Application No: A/2/25/PL
Site Address: 110 Downs Way East Preston BN16 1AF
Description of works: Demolition of existing detached garage and creation of 1 No. new semi-detached dwelling with associated landscaping and parking. This application is in CIL Zone 4 and is CIL Liable as a new dwelling.

Thank you for your internet representation made on 5th February 2025 which has been recorded as no objection with the comments as follows:

PROPOSED SITE PLAN

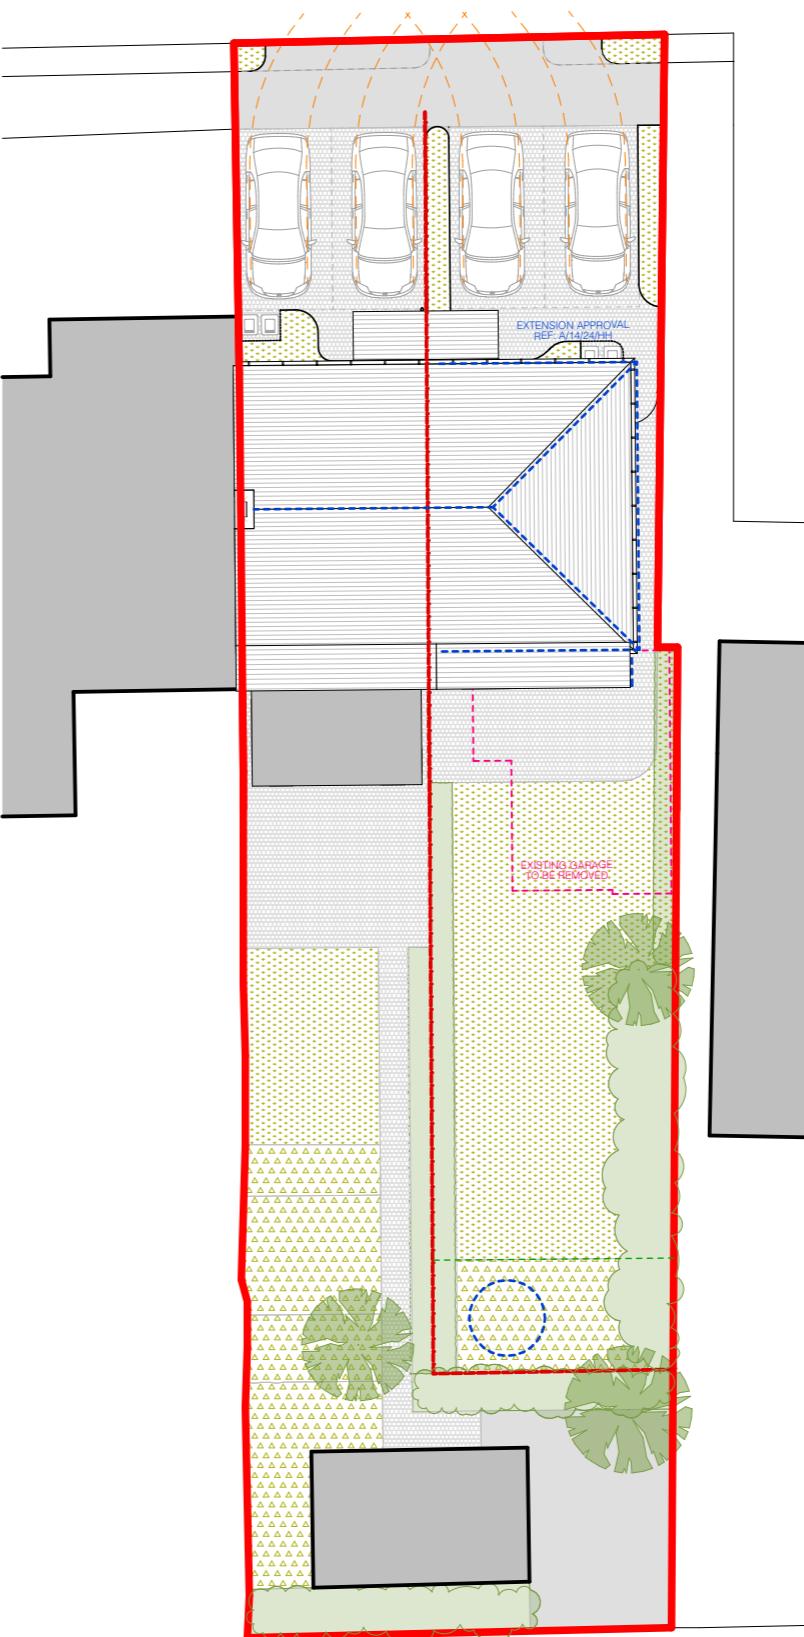
APC feels that consideration must be paid to the ADC Parking Strategy in an area where there is parking from the shoppers to the shops next door.
